Application No: EP/10/21/PL
Site Address: 4 Beechlands Close & east of 18 Beechlands Court Montpelier Road, East Preston BN16 1JZ
Description of works: Demolition of an existing garage & erection of 2 No. 2 bed dwellings (resubmission following EP/115/20/PL). This site is in CIL Zone 4 and is CIL Liable as dwellings.

Thank you for your internet representation made on 1st March 2021 which has been recorded as an objection with the comments as follows:

18 BEECHLANDS COURT, EAST PRESTON, BN16 1JZ	
Client	Description
c/o RSP ARCHITECTS LTD	PROPOSED SITE PLAN

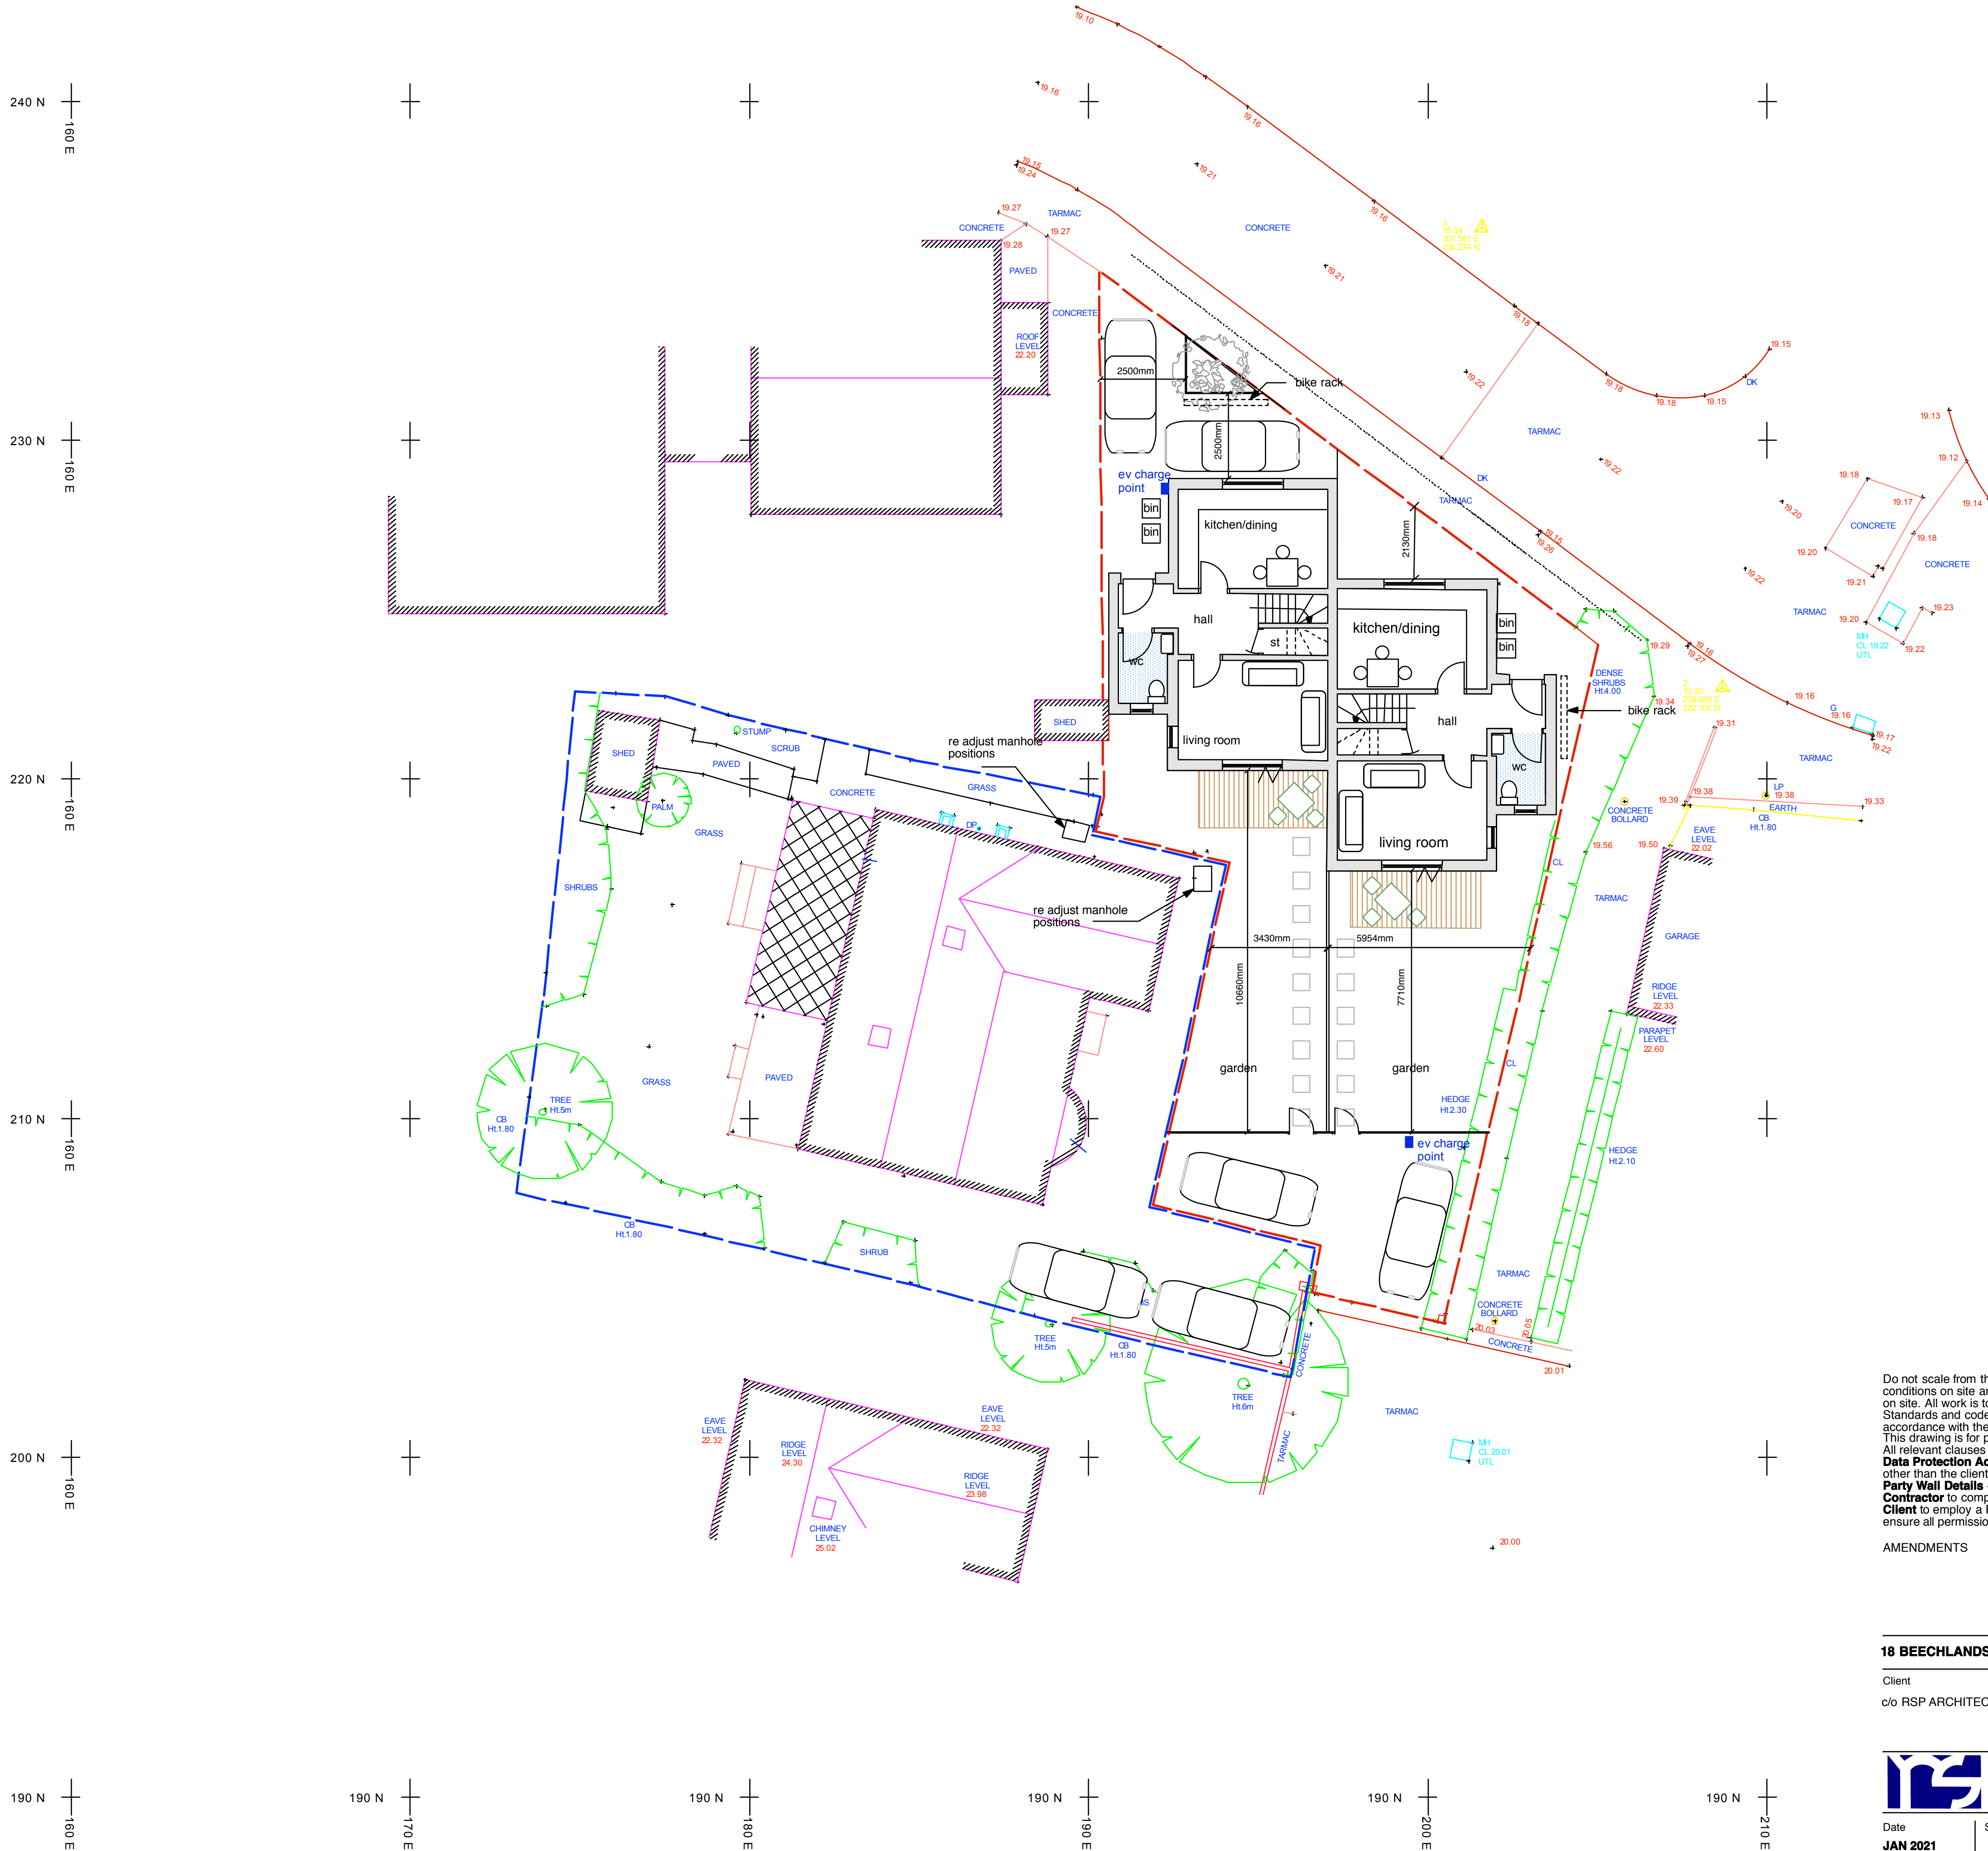
The proposal is to build two semi-detached properties on a plot of land on the corner of Beechlands Close and Montpelier Road. The properties have been slightly reoriented on the plot, but the committee remains concerned at the lack of amenity space with these two properties. Members still believe the resulting properties would appear very cramped on the site and would be out-of-keeping with the streetscene and the general spatial character of the area. Directly opposite the plot, the flats have attractive front gardens which enhance the area. Two properties on this plot, even with the increased off-street parking this proposal now provides, will lead to an increased demand for parking space in an already congested part of the village. We believe two properties on this plot will be overdevelopment. Concerns have been expressed by residents of Montpelier Road and Beechlands Close,
